CITY OF ALBUQUERQUE

January 9, 2023

RE: Circle K – 9620 Eagle Ranch Rd. NW
Conceptual Grading & Drainage Plans
Engineer's Stamp Date: No Date
Hydrology File: C13D028

Based upon the information provided in your submittal received 12/21/2022, the Conceptual Drainage Management Plan **is not** approved for action by the Development Facilitation Team (DFT) for Site Plan for Building Permit. The following comments need to be addressed for approval of the above referenced project:

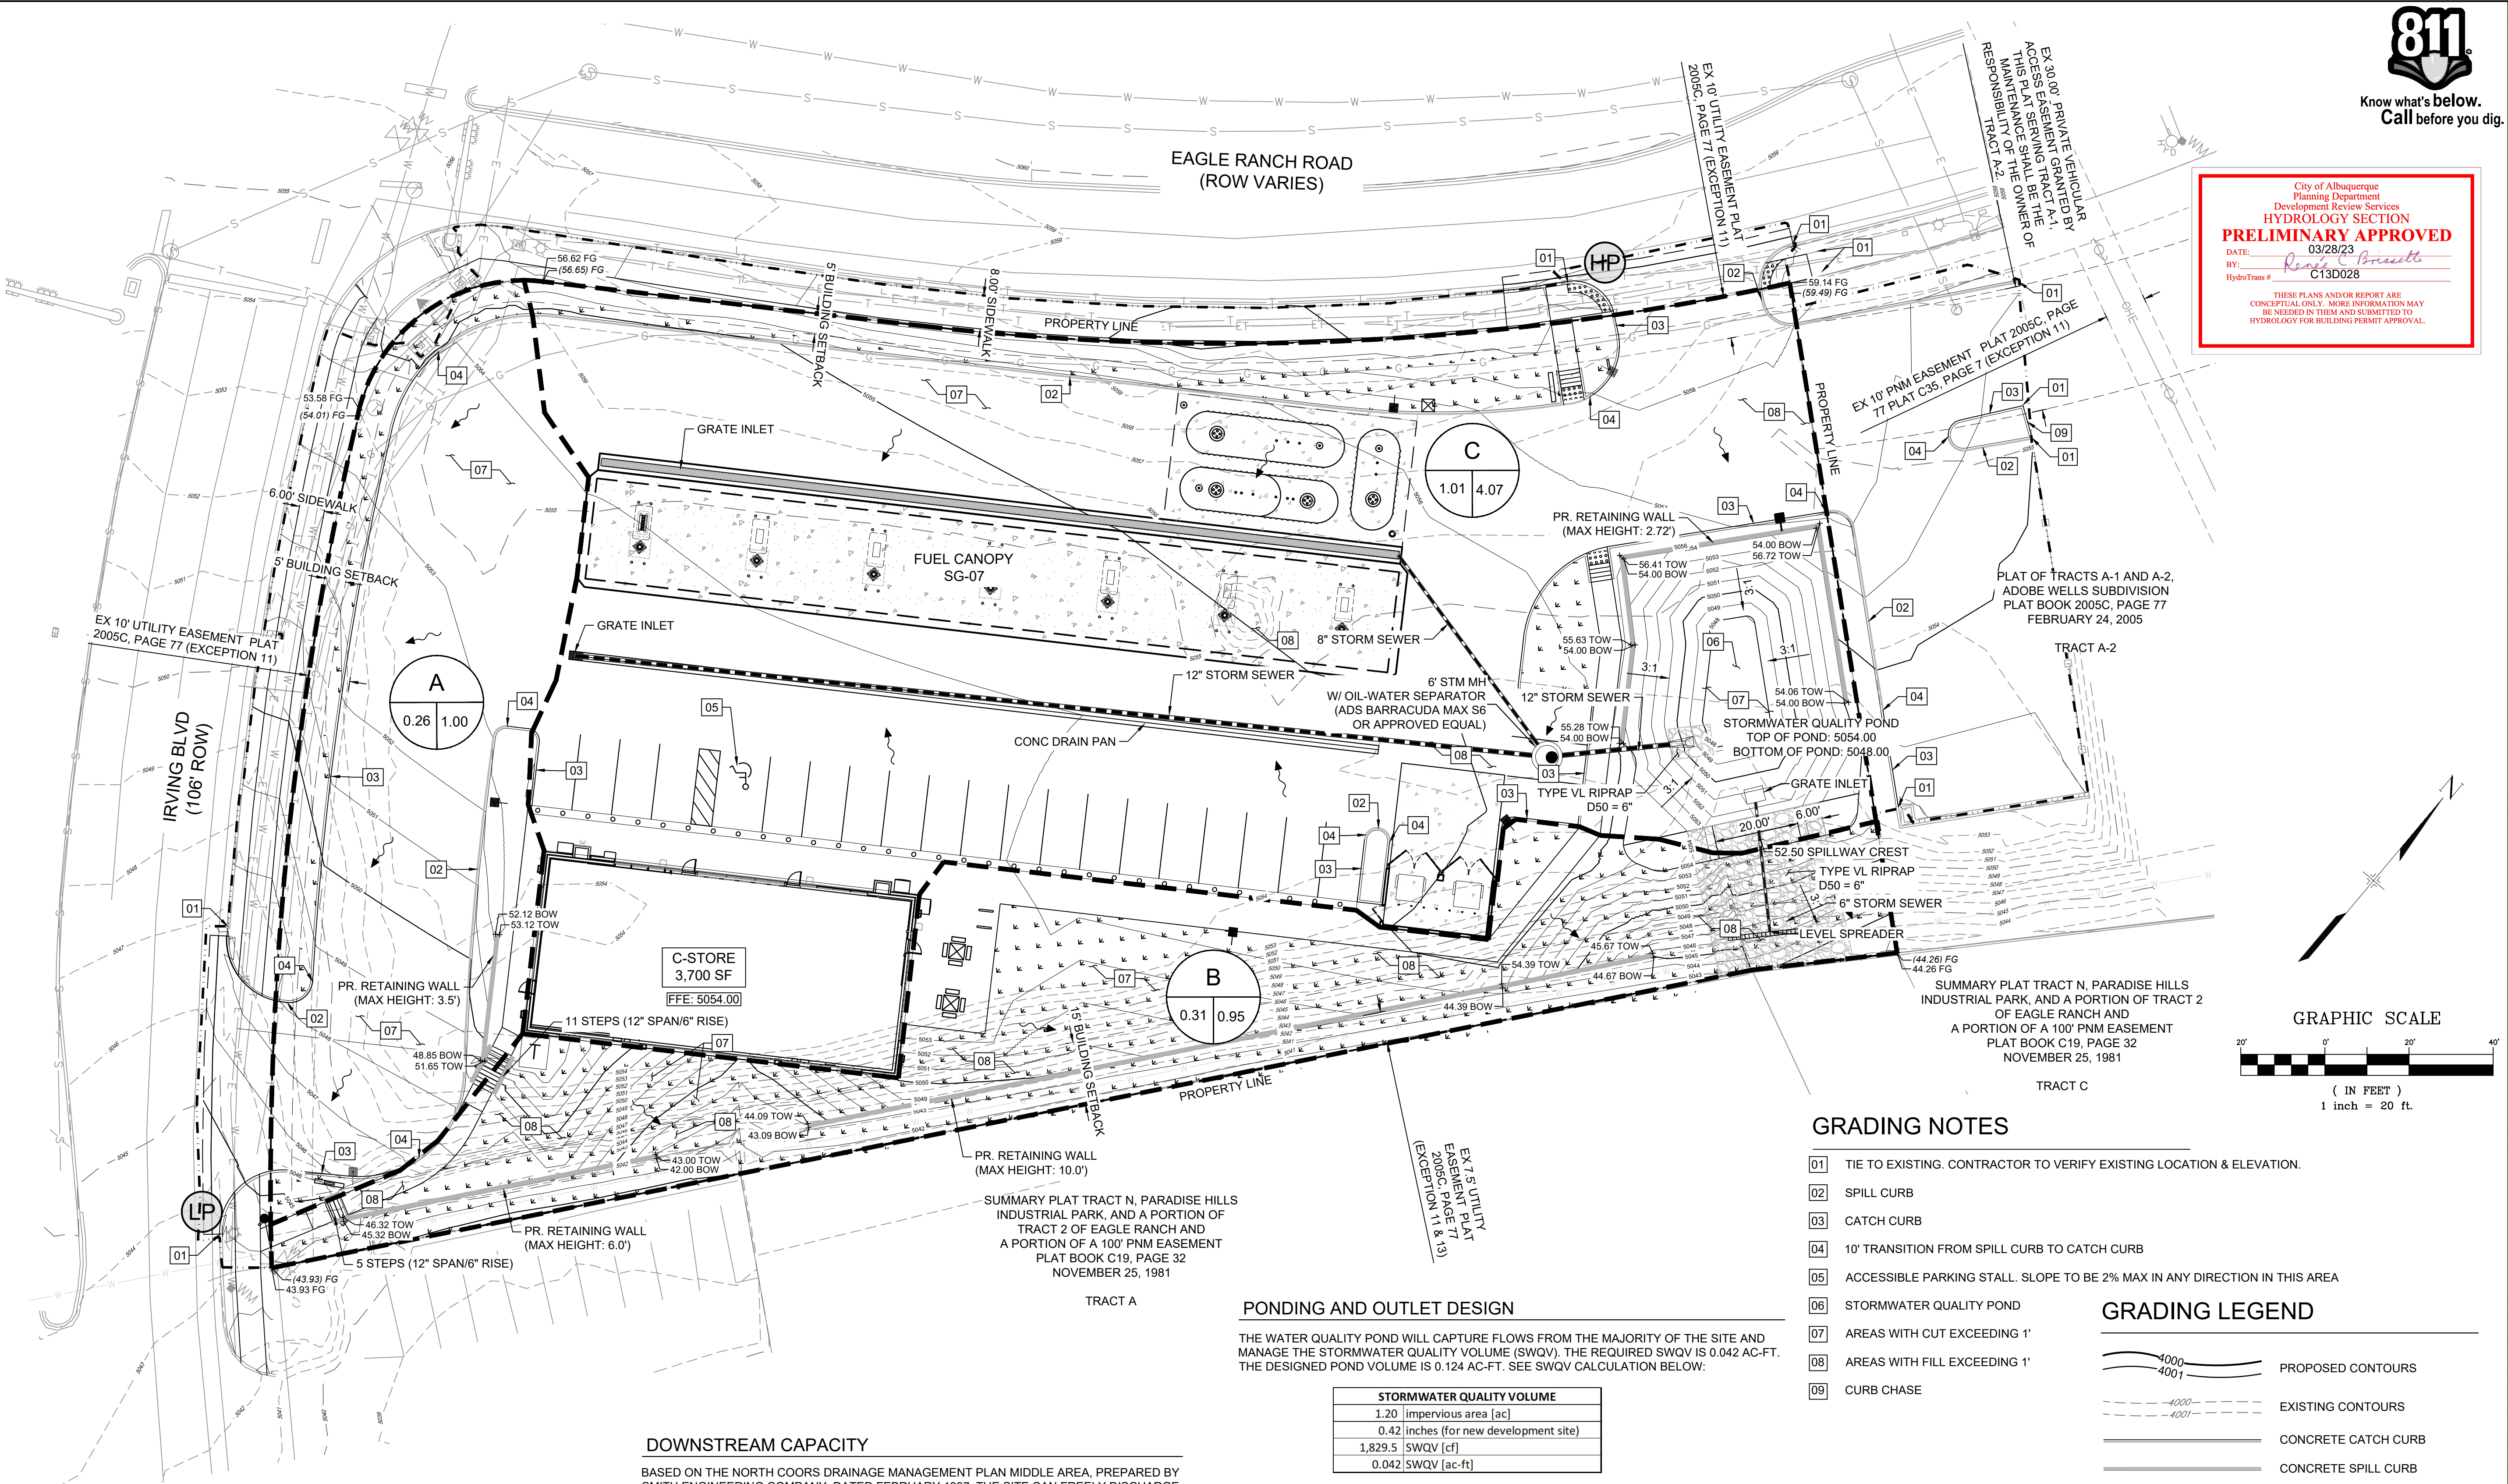
2. Please use the procedure for 40 acre and smaller basins as outlined in Development Process Manual (DPM) Article 6-2(a). Please provide both the existing conditions and proposed conditions for the 100 year-6 hour storm event.

3. Please follow the DPM Article 6-12 Stormwater Quality and Low-Impact Development for the sizing calculations. To calculate the required SWQV, multiply the impervious area draining to the BMP by 0.42 inches for new development sites. For this site, the impervious area is 1.24 AC or **54,014.4 SF**. Times the SF by 0.42 then divide by 12. This gets a required SWQ volume of **1,890.50 CF**.

5. All gas stations must drain to an oil/water separator (the Owner's choice) prior to discharge. This is mainly for the area around the pumps so some previous stations have placed this prior the remainder of the runoff going into the Stormwater quality pond. Since this site appears to be collected in a pipe system, instead of a manhole, this can be an oil/water separator.

- Please provide a 6-in swale along the south property line to direct the SWQ Pond's flow to Irving Blvd. At the R.O.W., please a 2-ft sidewalk culvert and reference City of Albuquerque standard detail No. 2236 – Sidewalk Culvert with Steel Plate Top at the sidewalk culvert.

SE POND PROFILE
SCALE: (H) 1" = 10' (V) 1" = 5'
START STA: 1+00.00, END STA: 2+11.76

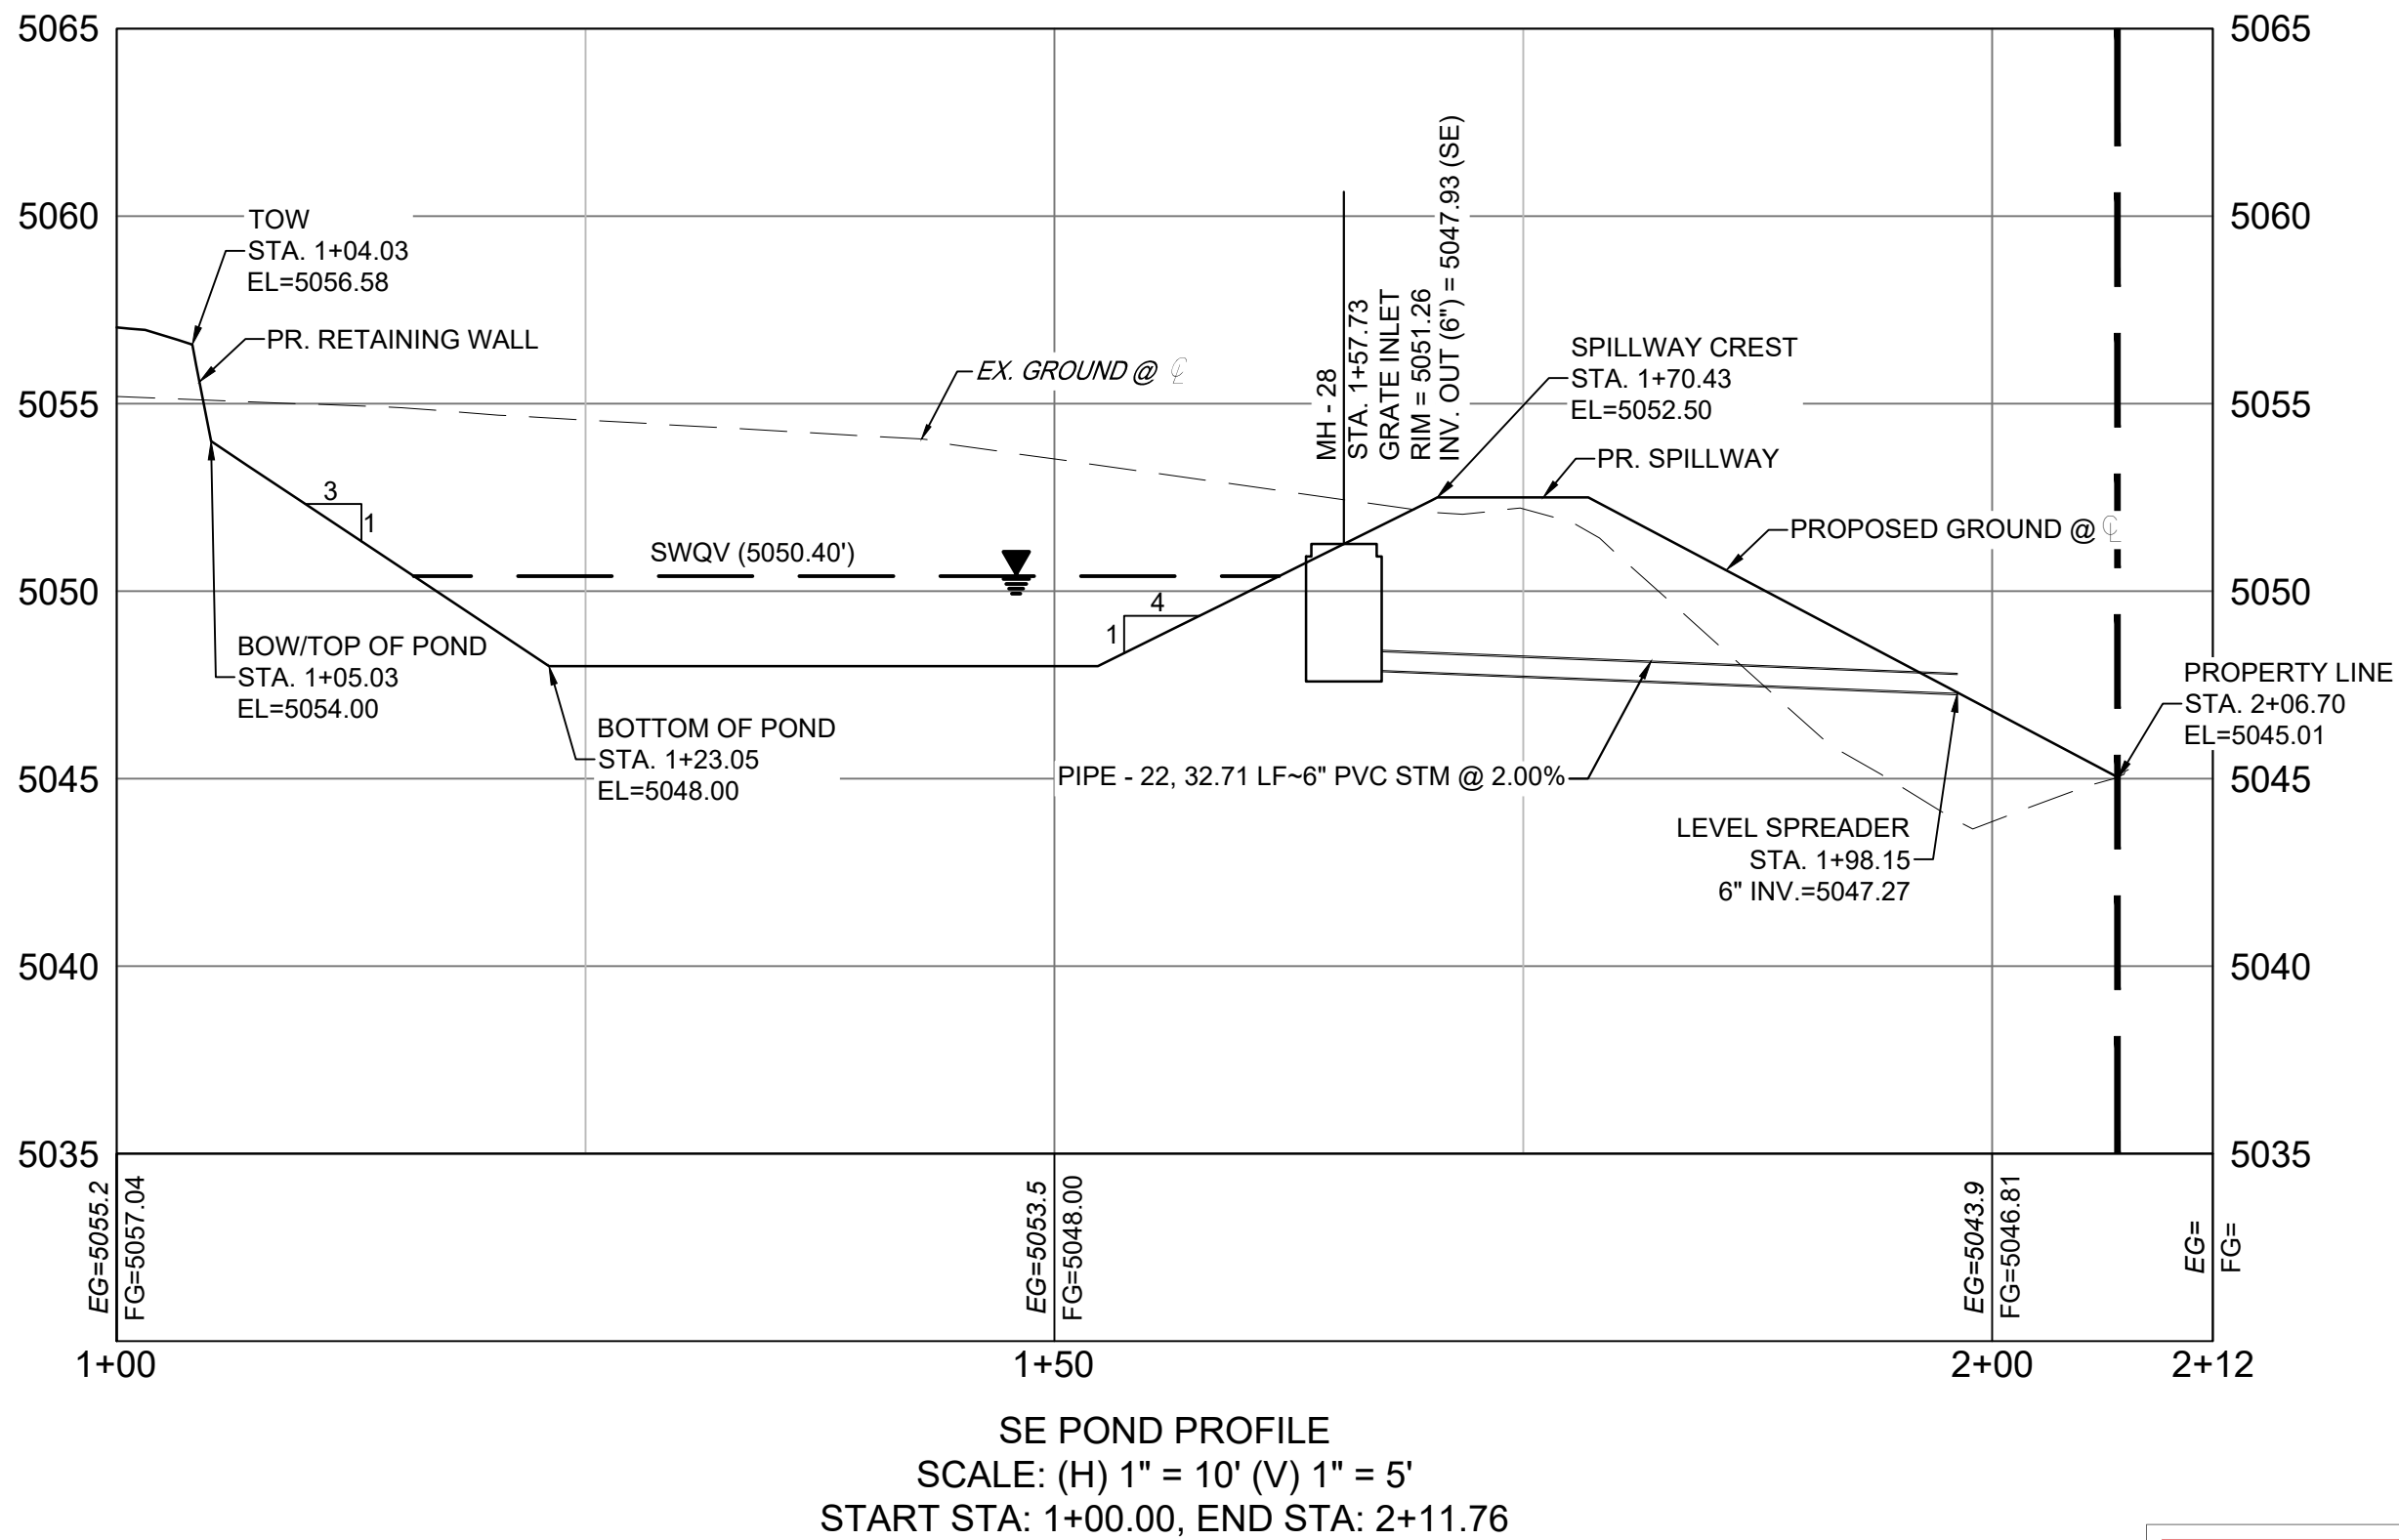
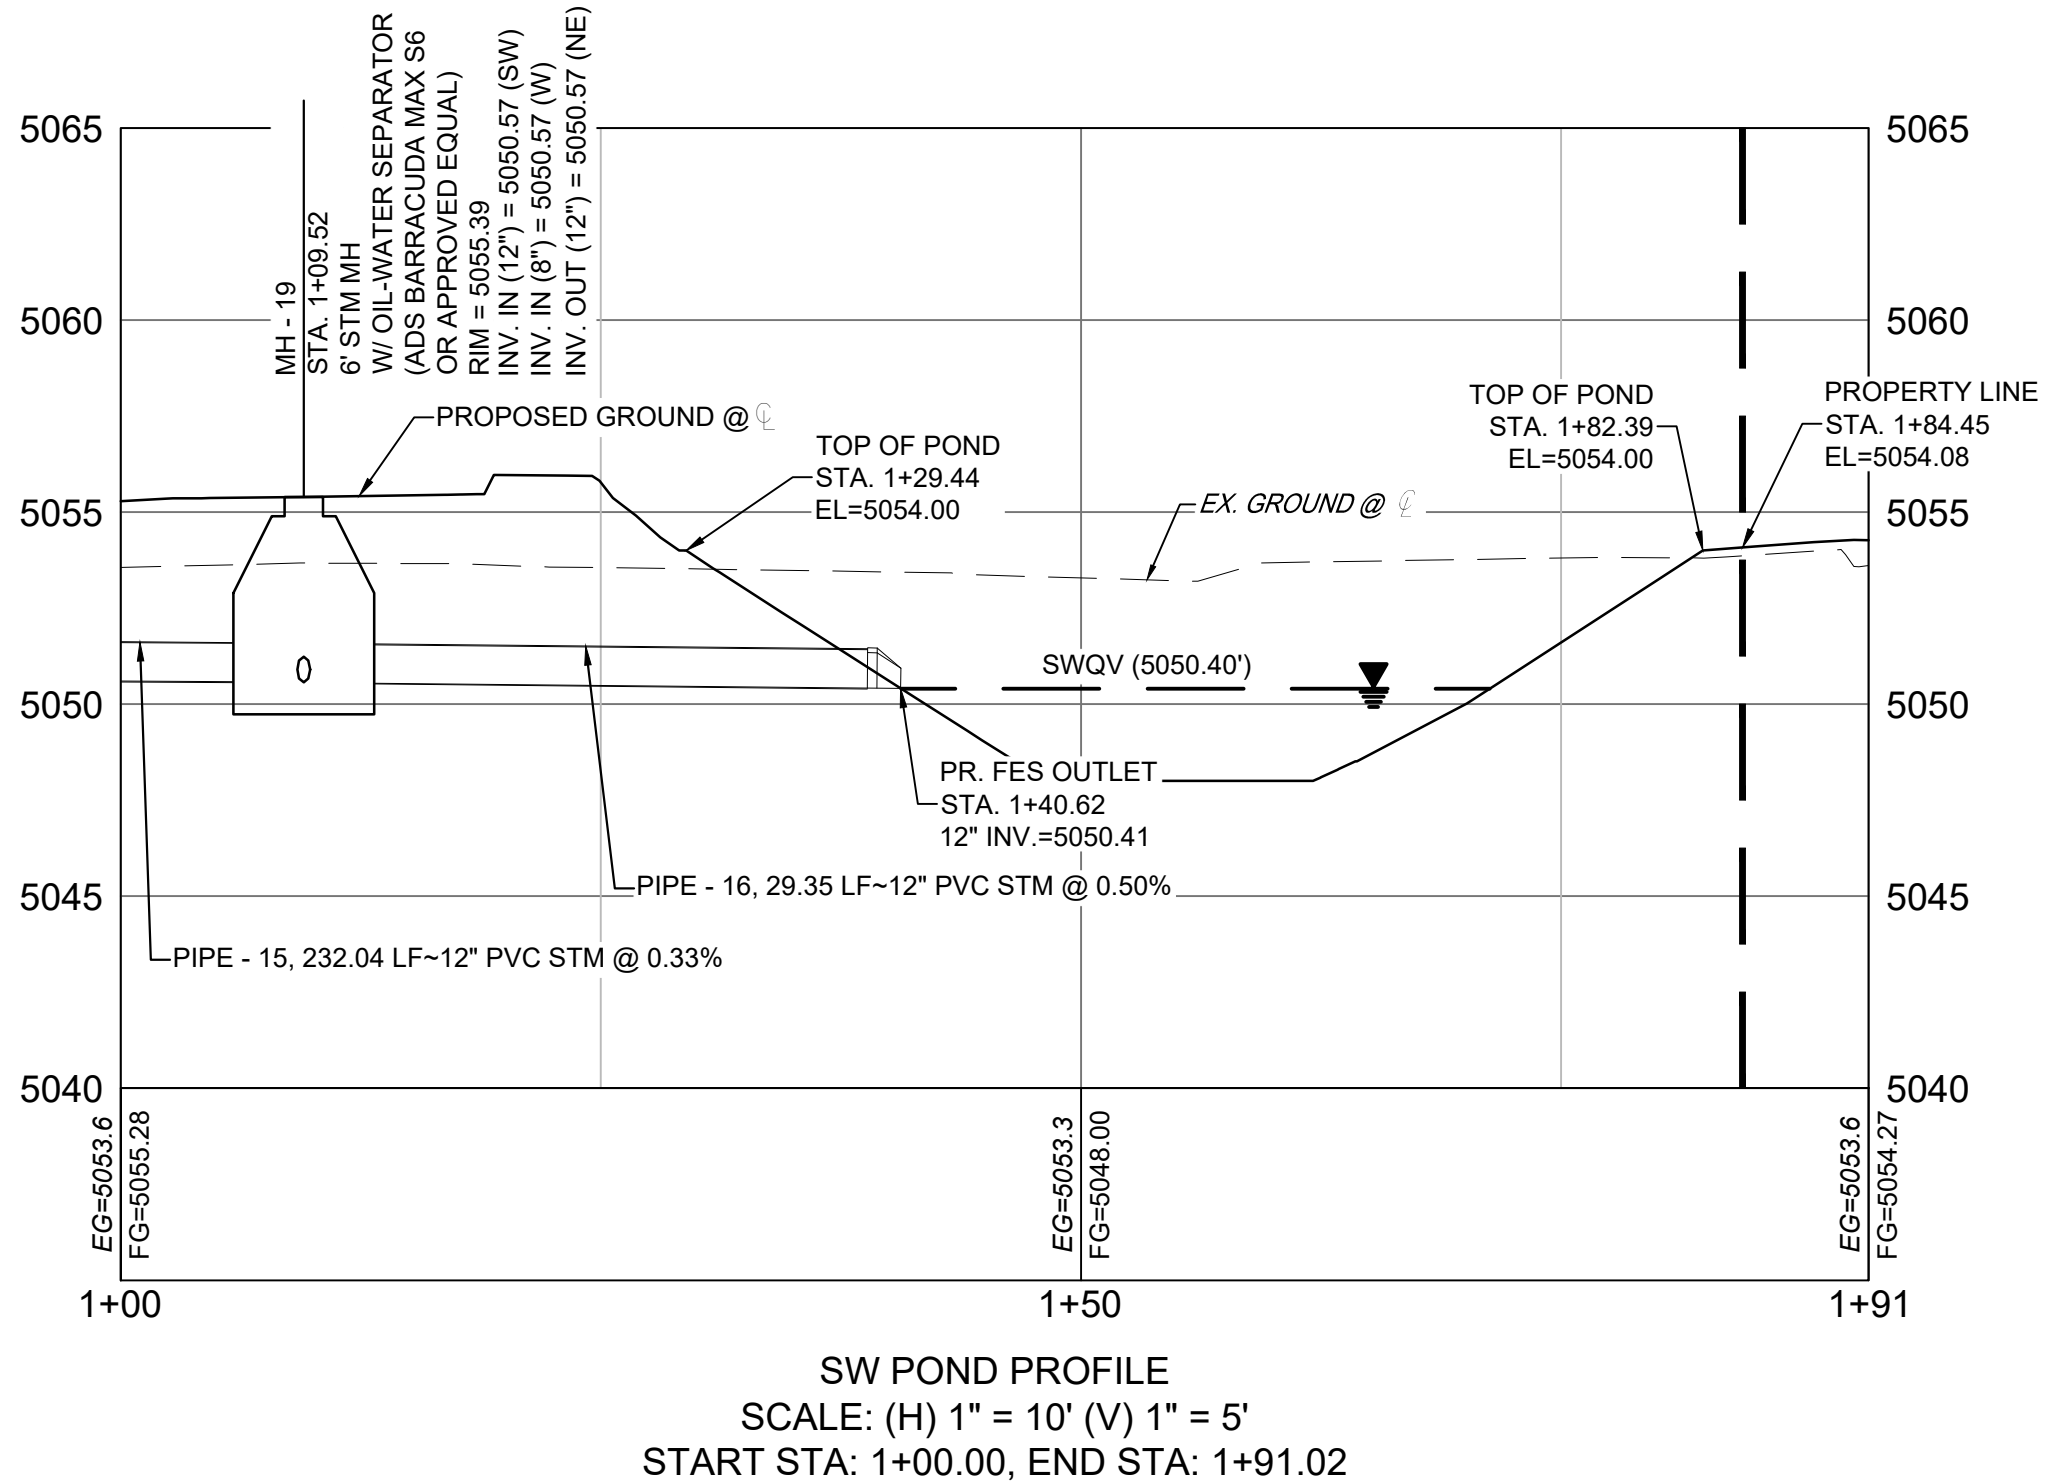
4. Please provide sections of the Stormwater Quality Pond. This should include the top of pond elevation, bottom of pond elevation, side slopes, Stormwater Quality water surface elevation (the required volume). Also include items such as retaining walls, pipes with inverts coming into the pond, and the outfall structure or emergency spillway.
